**From:** JOANNE ATTAWAY <4st4us@gmail.com>  
**Sent:** Wednesday, September 04, 2019 9:03 AM  
**To:** Chelsea Benner  
**Subject:** Rampart Row Short Plat (SP-19-00002)

RAMPART ROW SHORT PLAT APPLICATION

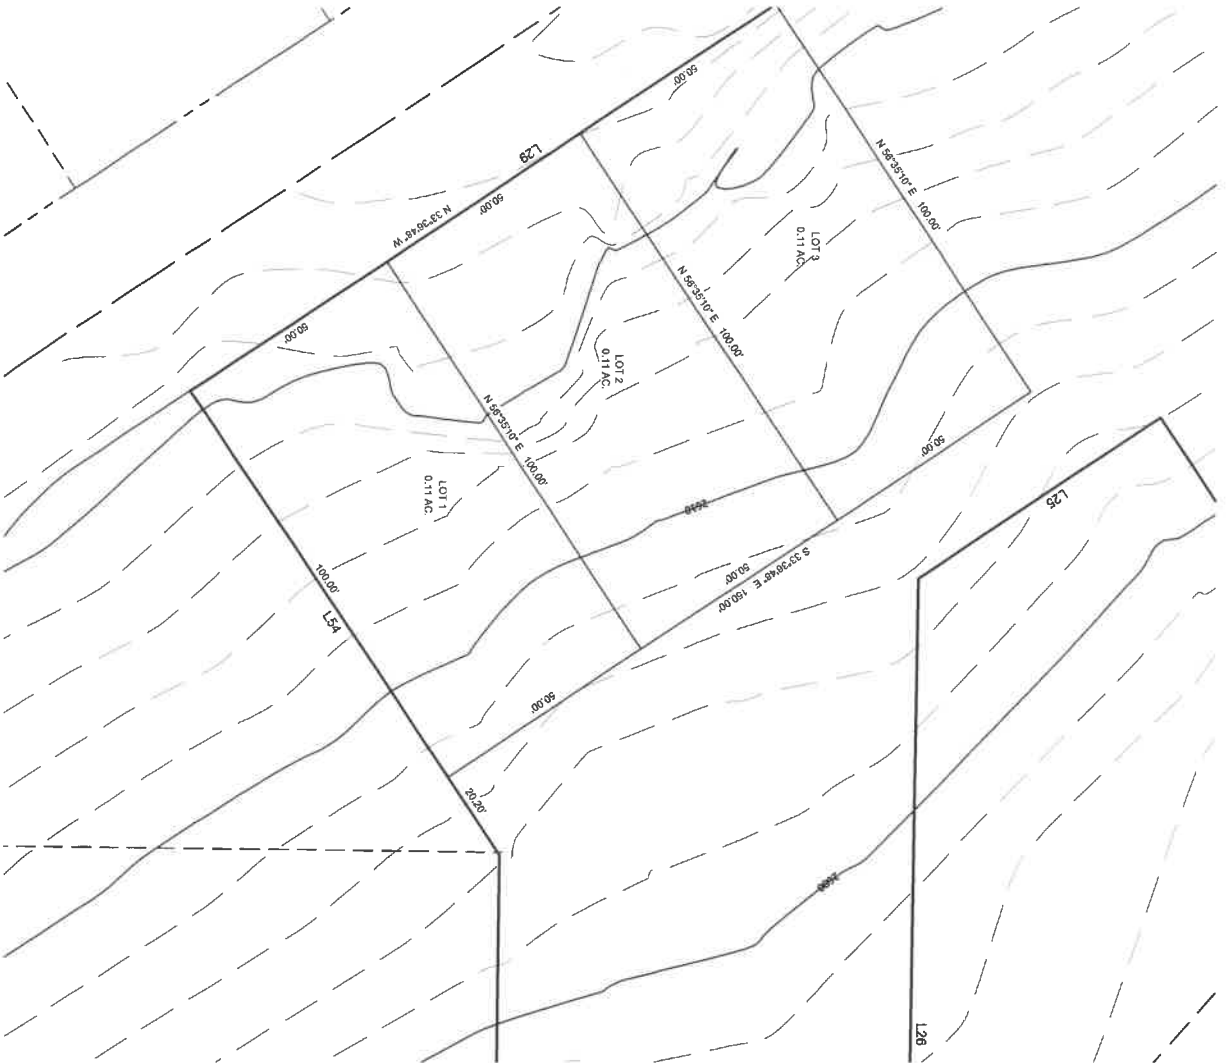
Dear Chelsea, We have a few concerns that we will list and hopefully get addressed by the new developers and the County. By the way, we have had a short informal meeting with them (the developers) as a neighborhood group. Most of our questions were answered there. BUT ( 1.) drainage is a huge issue around here. We have natural springs of water from the mountain sides. Plus the snow melt in the Spring. I realize it is the home

owners discretion on implementing a plan for their lots. When a developer group goes in, is it their issue? We see water problems on Rampart Dr across the street from our home. We are at 450 Rampart Dr. (2.) Is a hot tar roof really legal here? Most of the homes here, maybe ALL, have metal roofs for protection against fire. A tar roof was put on the house on lot 35 (?) 2 lots from us. (3.) It looks like the property high on the mountain behind us has also been purchased. It is extremely steep. Water will be a HUGE issue if building takes place there. (4.) Set backs for homes in the area certainly

must have room on the street for snow removal. So far our county has done an excellent job getting most of it off the street. Mainly because we have the extra room with the vacant lots to blow it on. Now that it's being developed, we believe maximum space should be provided in front and between houses. Hyak HPOA had a 25' setback that really helped and setback for each side of the home, plus height regulations.. I'm not sure that the new houses will buy into the HPOA. (5.) In an emergency situation, is there enough roadway to exit the entire neighborhood onto

Road 906 and then I-90? At present we only have ONE exit to the entire community. We have to remember that there is also a ski resort inside our community. (6.) Off street parking is also an issue. We currently have homes that are used for rentals. Some that house a large number of folks. Along with the overflow from skiing there is a HUGE issue with getting emergency vehicles in and out, let alone full time residents. We truly wish parking tickets would be issued by the county. It would satisfy a lot of the "lack of revenue" we are constantly reminded of. (7.) Will

ALL of the buildings comply with some kind of code that will not block views? Thousands of dollars could be lost by the current homeowners if that is overlooked. This would be addressed in the set back etc regulations i suppose.
